# TOGA Central, Henry Deane Plaza, Sydney Landscape RTS Submission

Prepared for TOGA  
December 2022

Response to submission

Image 2: Comparison of Test Awning and Proposed Awning Extension
(Source: Bates Smart)

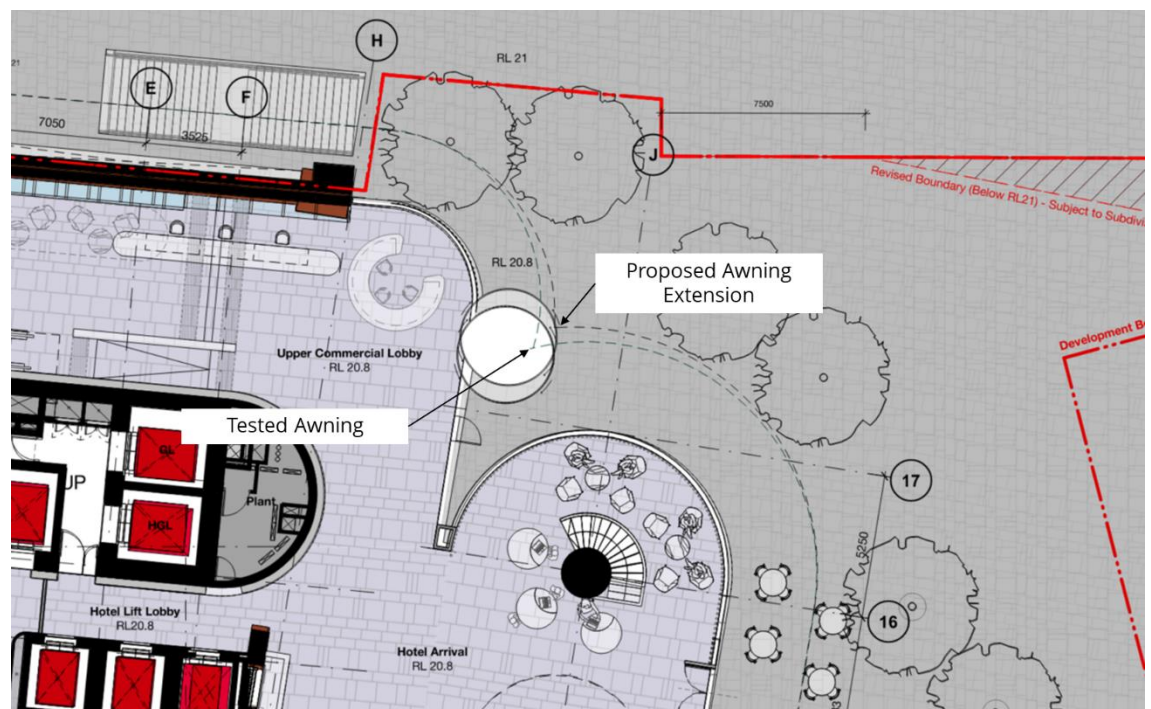
<p>4.3 Wind</p> <p>The Wind report prepared by RWDI discusses wind tunnel test results that were carried out at 1.5m above pedestrian accessible areas. A reliance on landscaping on the podium, tower and rooftop levels to mitigate winds is not supported, as trees and landscape on upper levels that are wind impacted can fail and are difficult to replace post construction. Any mitigation measures should be completely integrated into the architectural design of the building and wind tunnel testing should be provided to confirm the design is safe for use. Additionally, it is noted that the tower awning at ground level appears to dissect proposed palm canopies, suggesting that the building design is not coordinated with the landscape.</p> <p>Recommendations:</p> <ul style="list-style-type: none"><li>• Wind mitigation methods must not rely on trees and landscape. If wind mitigation measures are required, this is to be integrated into the building design and further wind tunnel testing is to be provided.</li><li>• The tower awning is to be designed having regard to the landscape design.</li></ul>	<p>Palm Trees have been coordinated with the awning, refer to landscape plans on page 20-24</p>

Figure 6: Arboricultural impact assessment

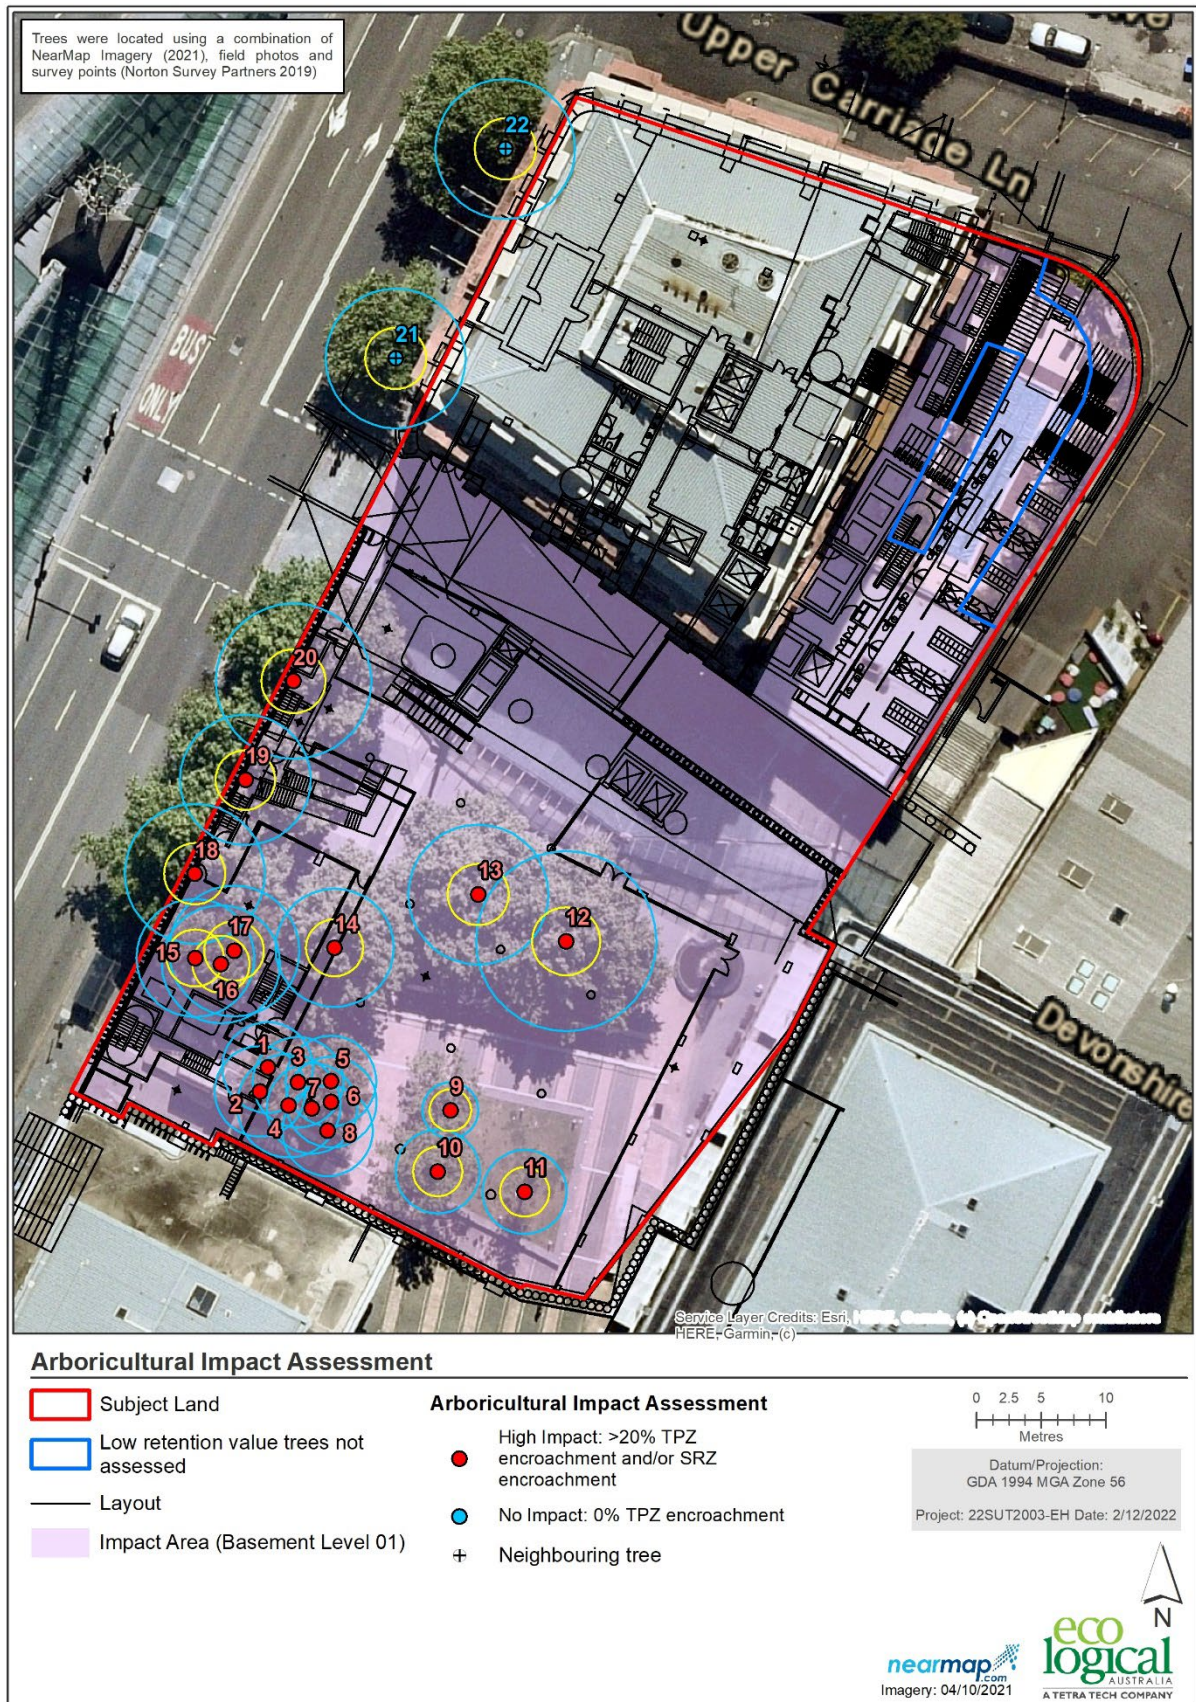
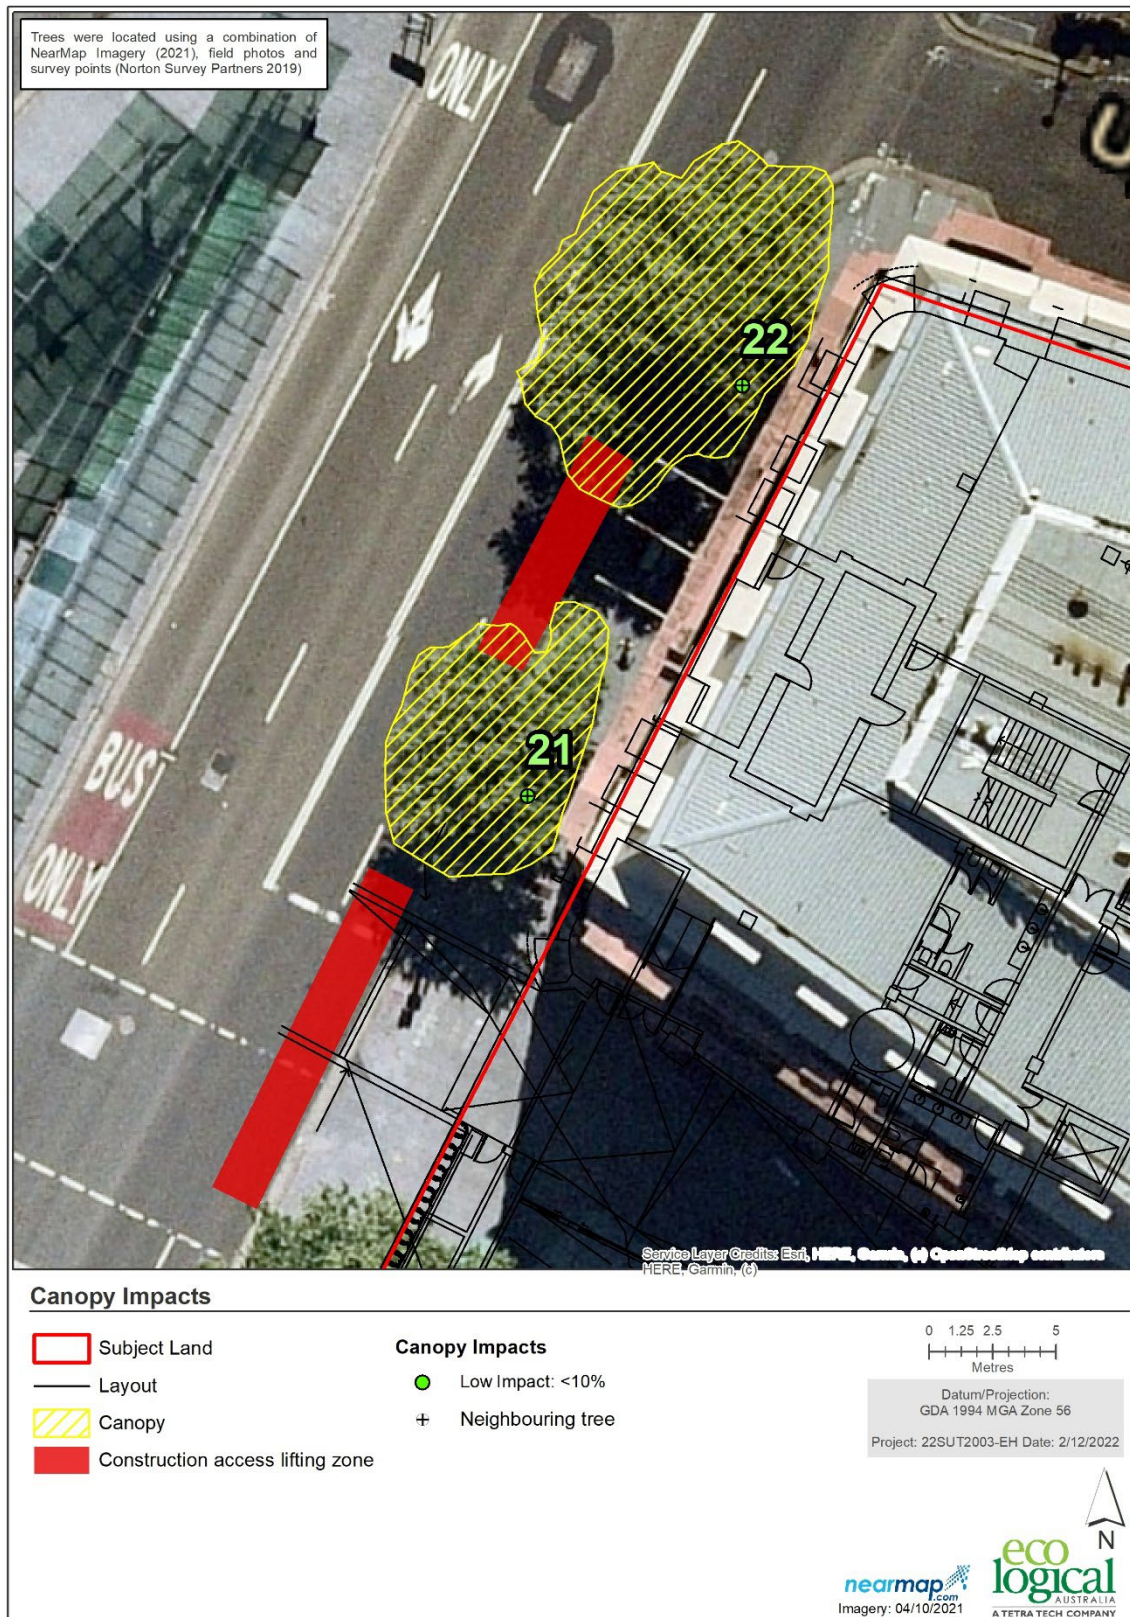
<p>The City has no objections to the removal of Trees 1-17 as these trees will be directly impacted by the footprint of the proposed development.</p> <p>However, the City does not support the removal of Trees 18-22 (<i>Platanus x acerifolius</i> - London Plane Trees), which are noted as being of high retention value in the AIA.</p> <p>Trees 18-20 are located adjacent to the Lee Street frontage in an area that is to be retained as public domain. The location of the trees adjacent to a site boundary generally makes tree retention more feasible than trees located centrally within the site.</p> <p>Trees 21 and 22 are street trees located within the Lee Street road reserve. The Landscape Report outlines that these trees are proposed for removal as they will limit construction access and are not a suitable species due to being constrained between the heritage facade and the road. The City does not agree with these assertions. The trees have developed a slight phototropic lean away from the building and have been pruned early in their development for building and pedestrian clearances. With additional pruning works and protection, construction access is achievable. The crowns of the trees are not restricted on the roadside, and it is commonplace for street trees to have an asymmetrical crown form to accommodate a building on one side. Therefore, the removal of these large, healthy community assets is not supported by the City.</p> <p>Further, the AIA does not provide an adequate assessment of the impacts on Trees 21 and 22. The Report notes that Trees 21 will be subject to a 'medium impact' and Tree 22 will be subject to a 'high impact' with no further details provided on what these impacts are. A more detailed assessment of impacts (noting that the existing heritage building within the Tree Protection Zones is to be retained) is required.</p> <p>Trees 21 and 22 are street trees and together with Trees 18-20, they form a row of single species along the Lee Street frontage which provides significant shade and amenity to the site. They also provide the existing context for the frontage of the heritage building behind. It should also be noted that the existing street trees (also <i>Platanus x acerifolius</i> - London Plane Trees) adjacent to the Dexu Frasers site are proposed to be retained, maintaining the continuous row of healthy, mature trees along the Lee Street frontage.</p> <p>The removal of high Retention Value trees should be avoided wherever possible, particularly where their location does not substantially restrict development. Design modifications are recommended to allow for the retention of Trees 18-22.</p>	<p>Trees 21 to 22 have been updated to be retained. Refer to page 47</p> <p>Trees 18-20 however are located within the subject site and (similar to trees 1-17) will be directly impacted by the footprint of the proposed development.</p> <p>The proposed development cannot be feasibly set back from the boundary to enable the trees to be retained in place without very significant impact to the layout and efficiency of the basement design</p> <p>The dense canopy of the existing trees 18-20 will pose a obstruction to view lines and connectivity between Lee St, the plaza and the future over station development</p> <p>Replacing these trees will facilitate a strategic placement of tree canopy and will open the opportunity to select tree species that are endemic to place and aligns with a broader vision to connect landscape to country.]</p>
